LEVEL II/III REVIEW (14-526): 30 Merrill – 7 units

SUBDIVISION REVIEW (14-497)

PERVIOUS PAVEMENT SECTION DETAIL
NOT TO SCALE

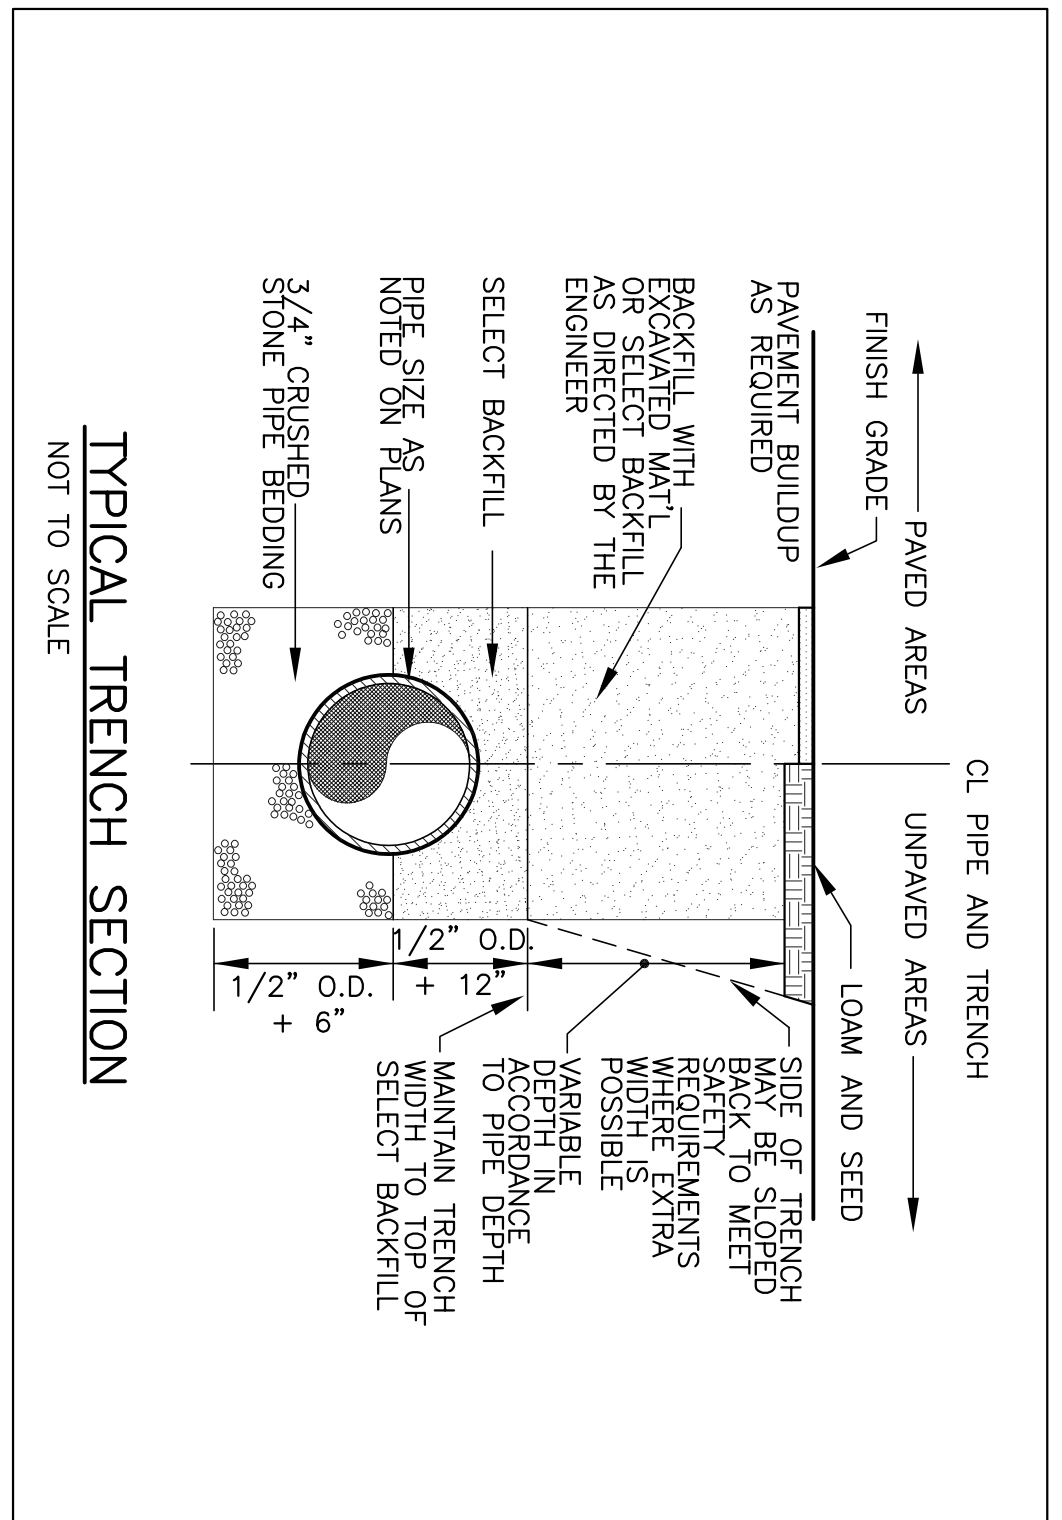
c. Water Quality, Storm Water Management and Erosion Control	<ul style="list-style-type: none"> • Are pervious pavers proposed within the center of the driveway or within all of the parking area? The stormwater report and plan appear to conflict • Based on response to above, confirm impervious calculations. Calculations in stormwater report appear to assume that entire parking area and driveway are pervious • Show where stormwater is proposed to enter the city's system 	<ul style="list-style-type: none"> •
Public Infrastructure and Community Safety	a. Consistency with Master Plans	<ul style="list-style-type: none"> •

BICYCLE RACK SPECIFICATION - BIKE HITCH

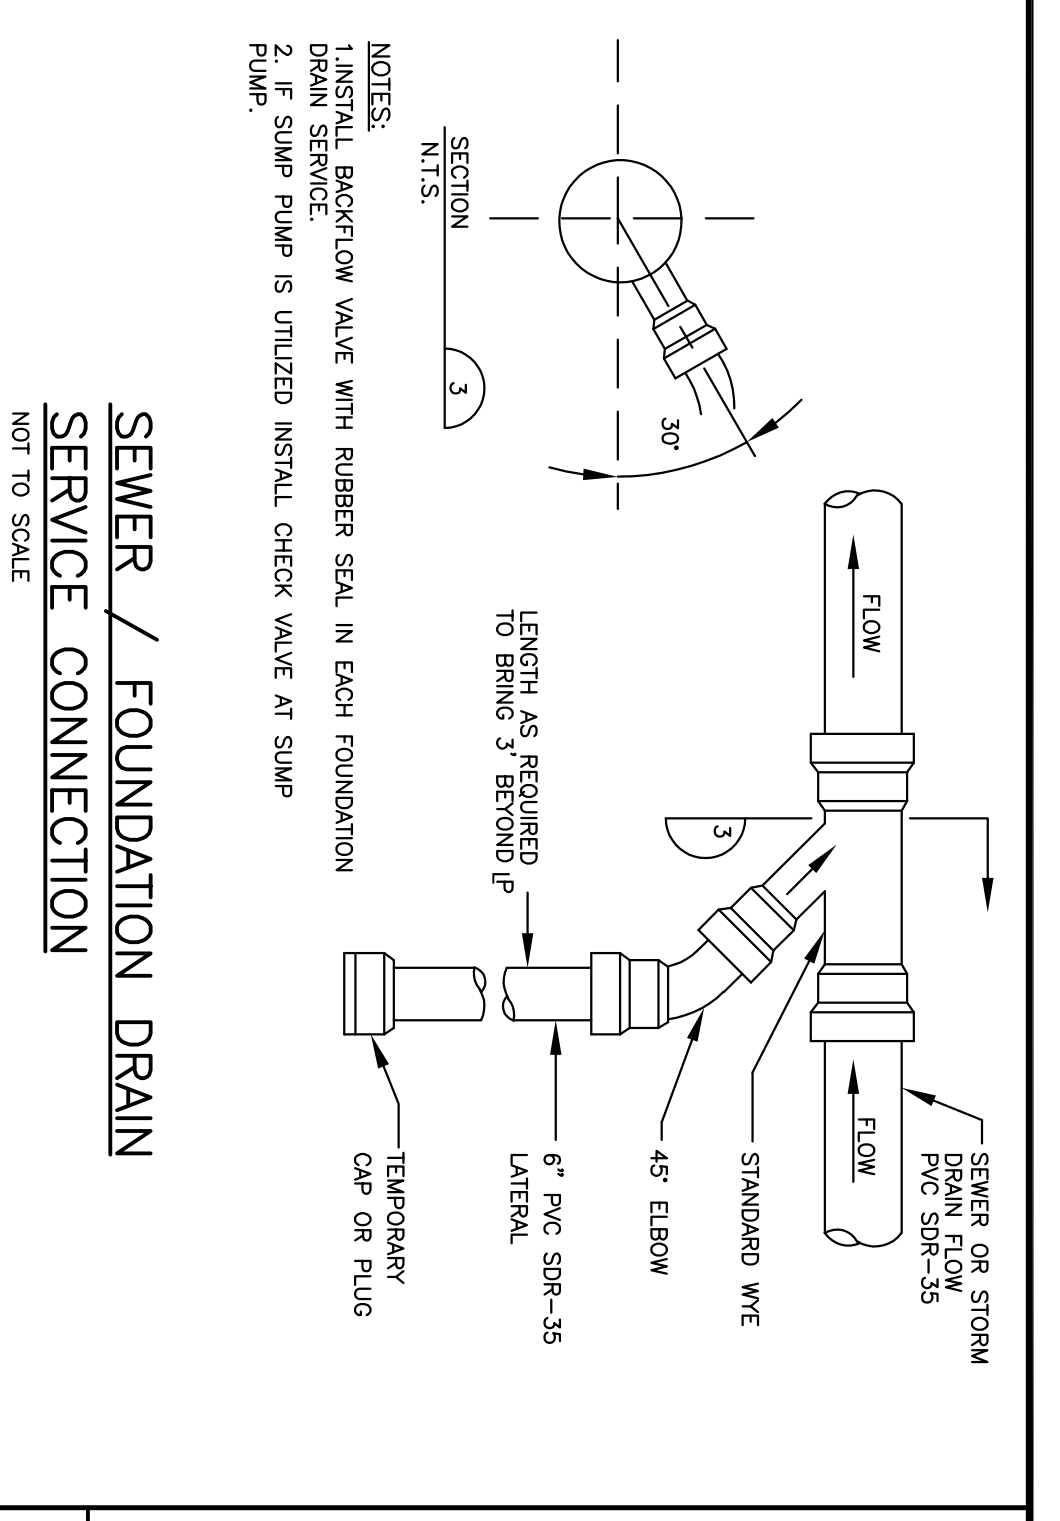
c. Public Transit Access	<ul style="list-style-type: none"> • N/A 	
	d. Parking	<ul style="list-style-type: none"> • <i>Bike parking standard:</i> <i>Residential – 2 spaces/5 dwelling units = 3 bike parking spaces.</i> Please show rack on plan and include detail. • Snow storage area will be inaccessible when cars are parked. Please revise or provide alternate plan for snow storage/removal. 	<ul style="list-style-type: none"> •

PROJECT NAME: SIX-UNIT BUILDING 30 MERRILL STREET
 PORTLAND, MAINE
 SHEET NAME: SITE LAYOUT PLAN

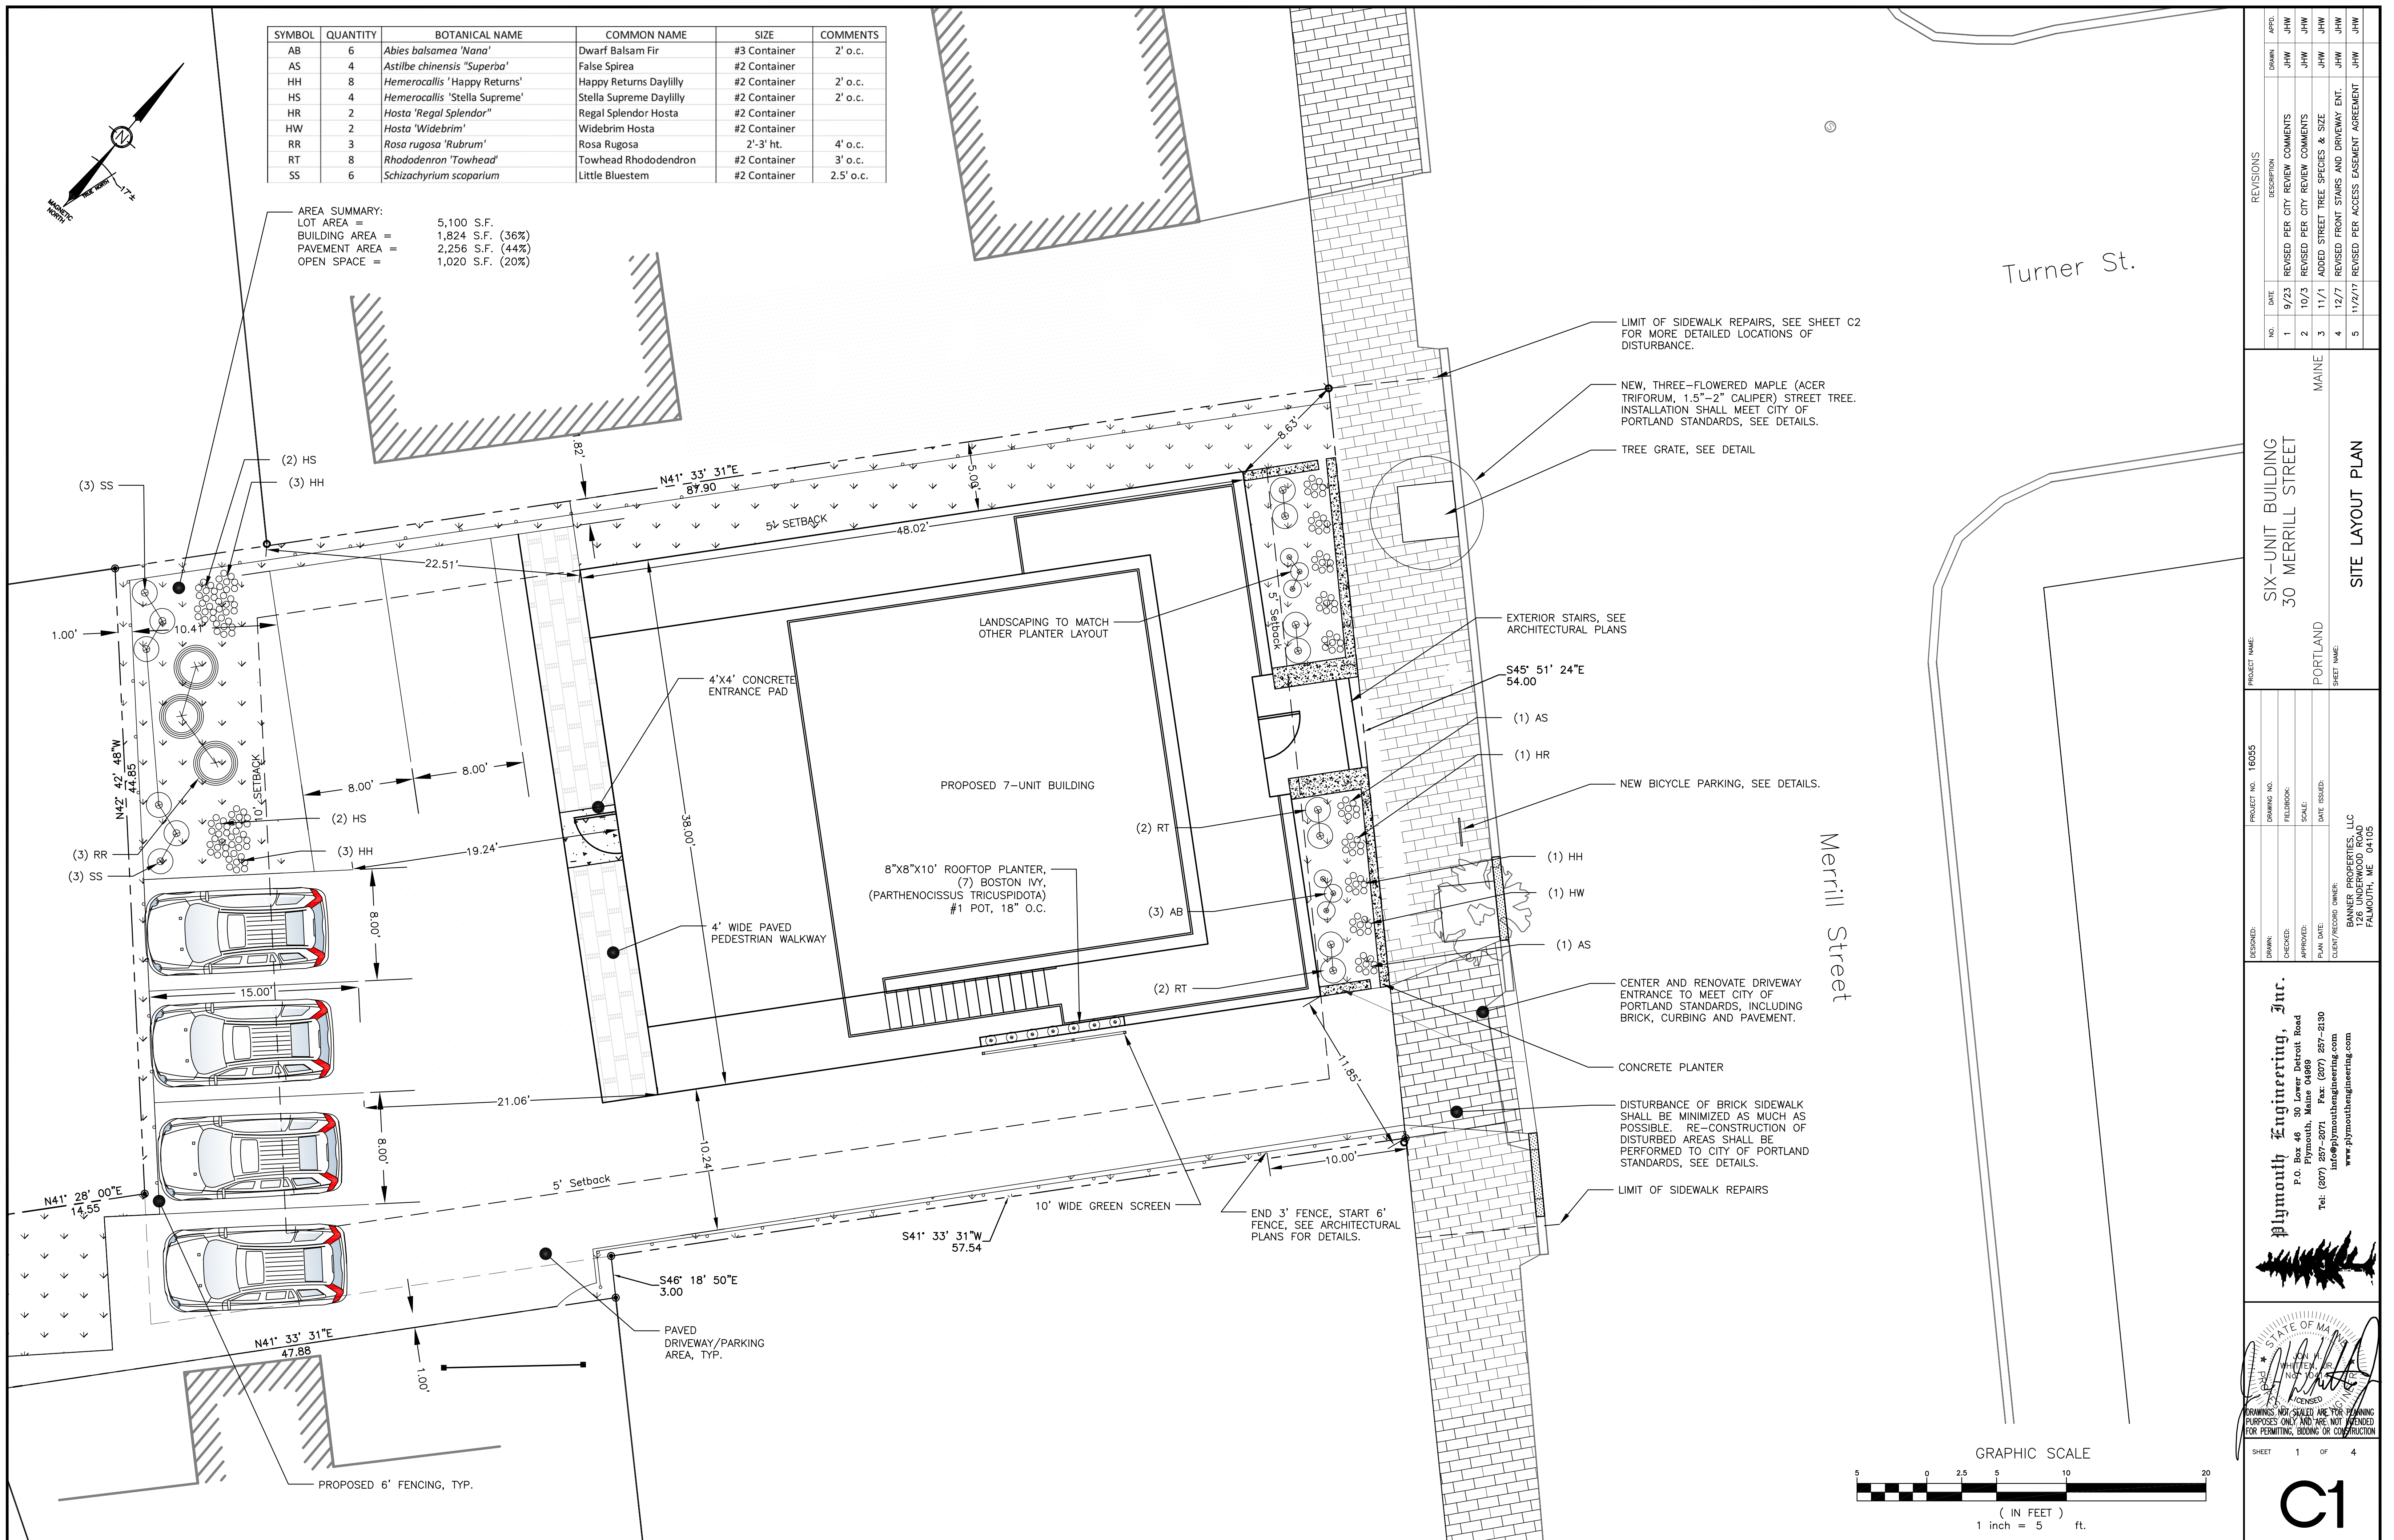
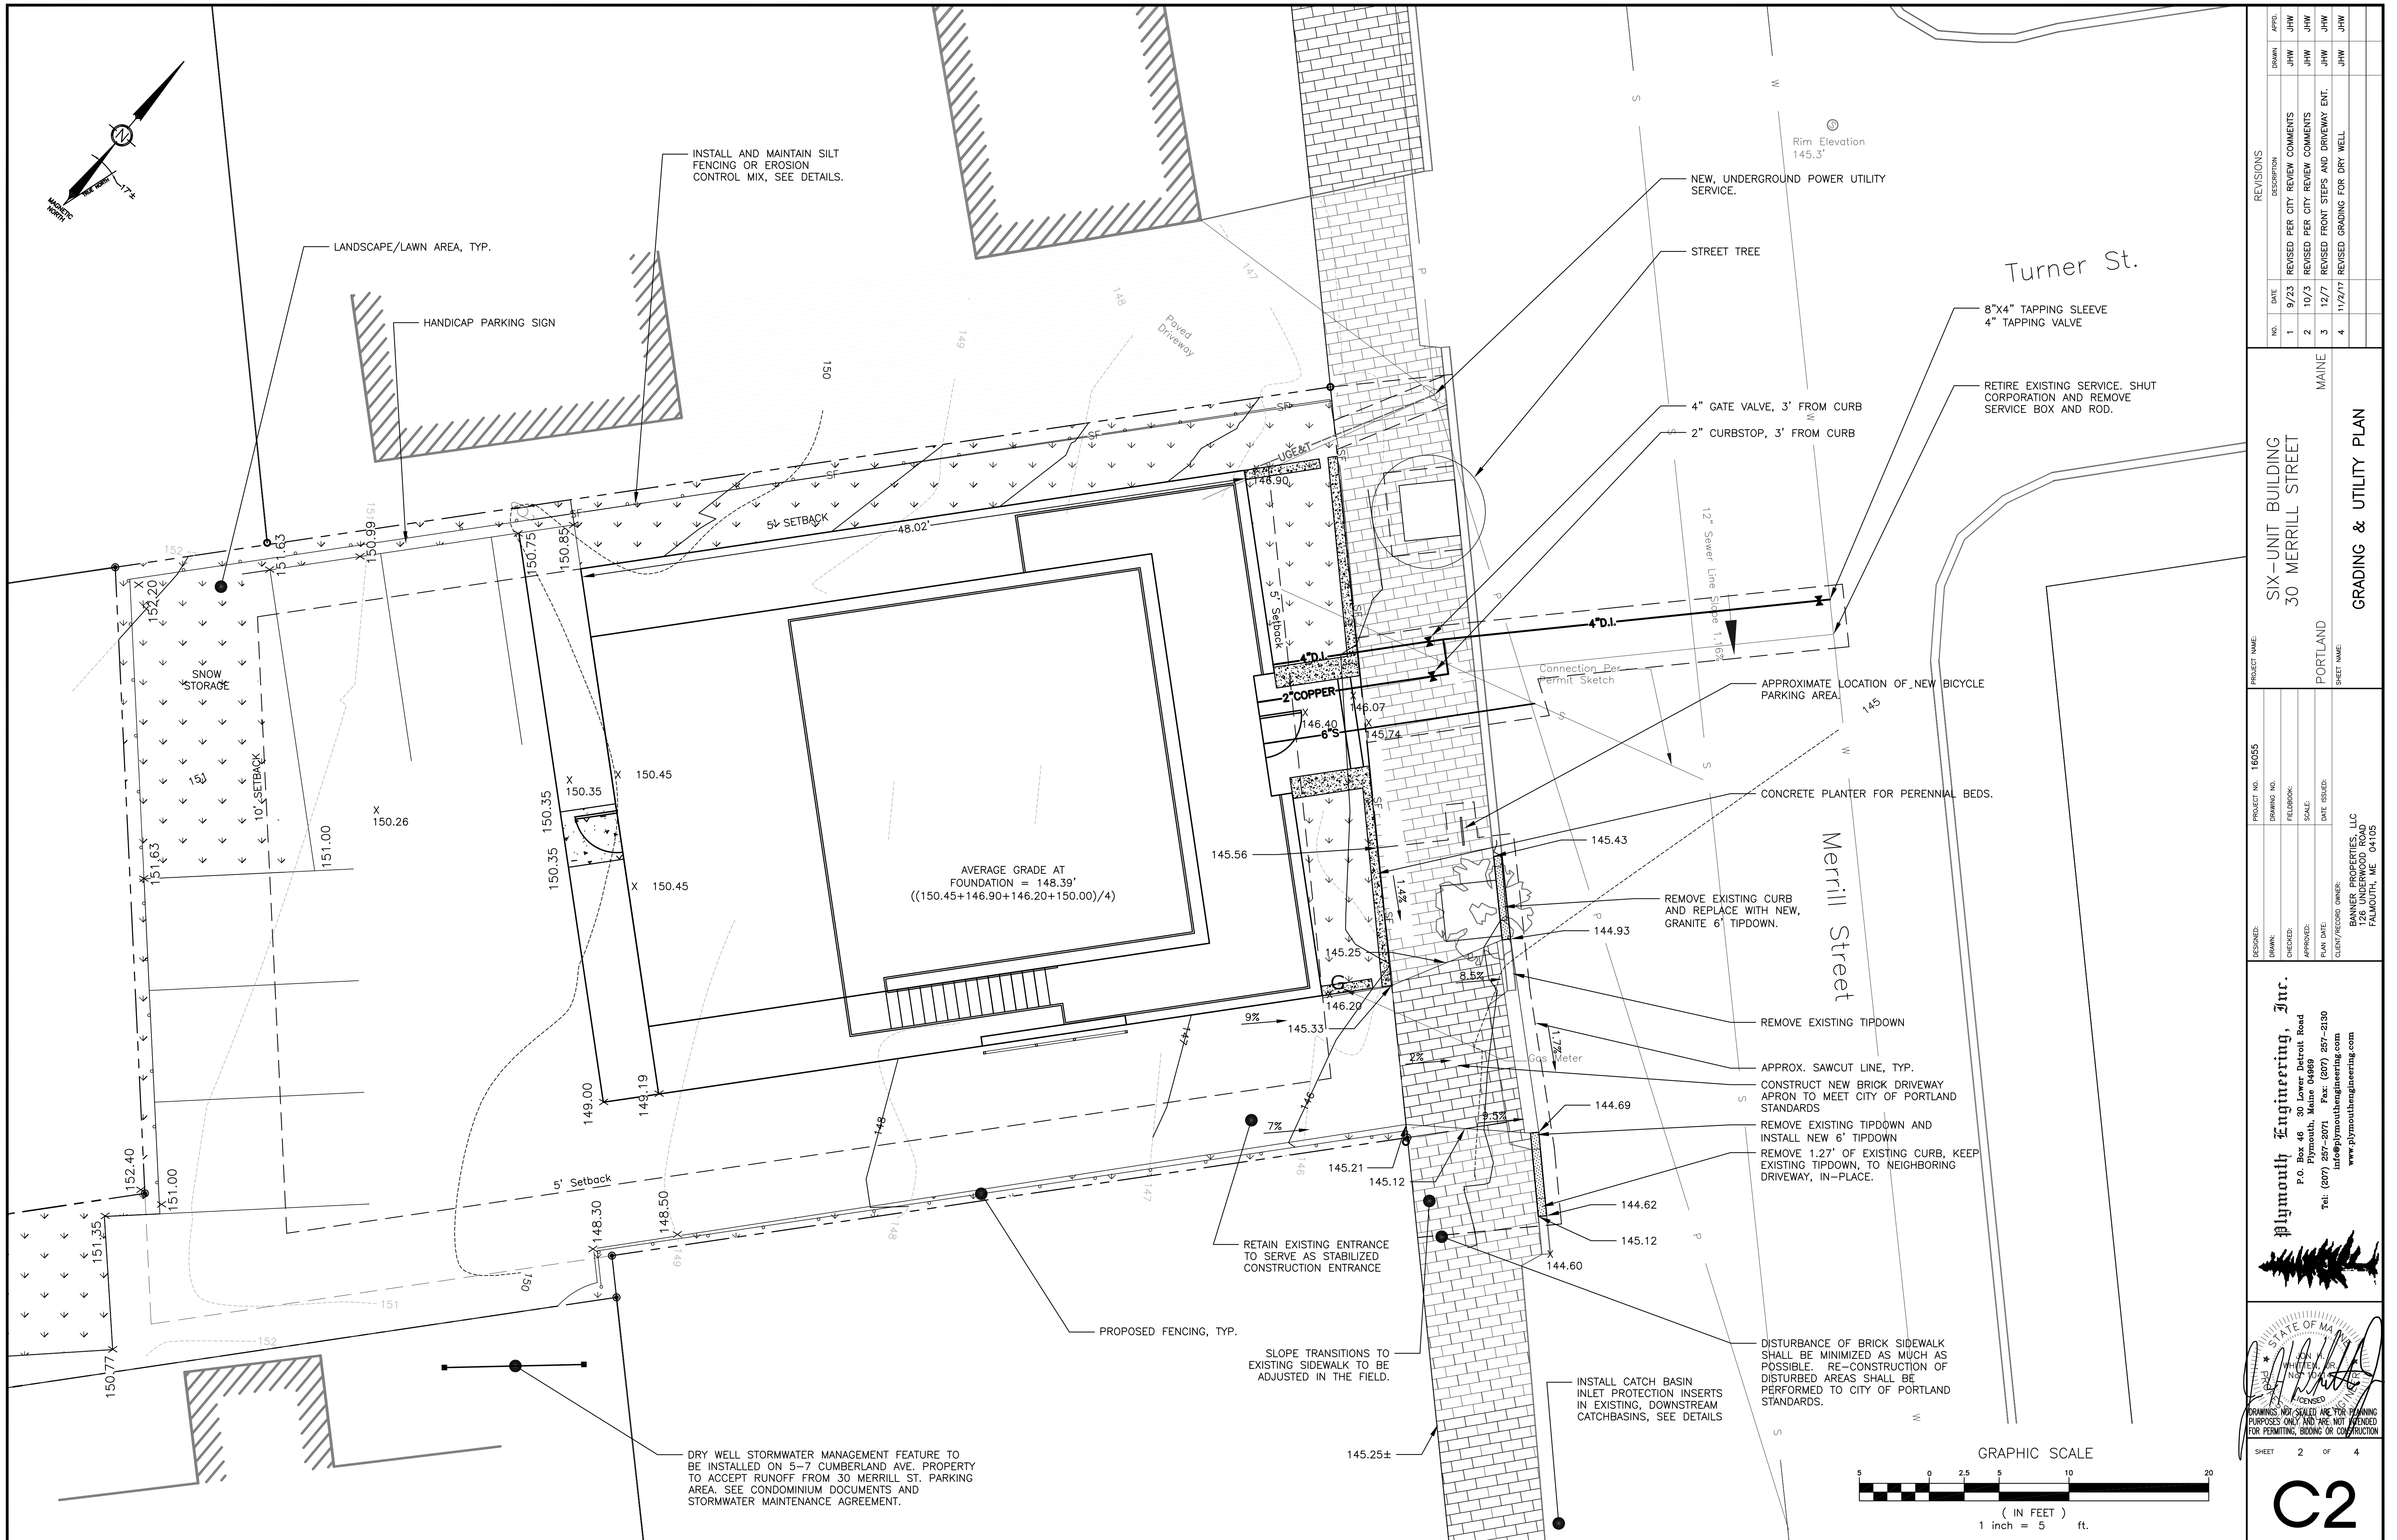
- Please define areas that were included as open space in the calculation in order to confirm that plans meet 20% open space requirement.

- Clean up extraneous lines (e.g. SW corner of parking area)
- Eliminate references to 'impervious patio?'
- Add north arrow
- Show distances to property lines from all building sides and from parking area
- Show important dimensions (e.g. aisle width in parking)
- Confirm curb cut location, as it appears to show slightly differently on survey
- Show exterior doors
- Show bicycle parking on plan
- Show areas of sidewalk repair
- Need grading/drainage plan that shows stormwater treatment plan
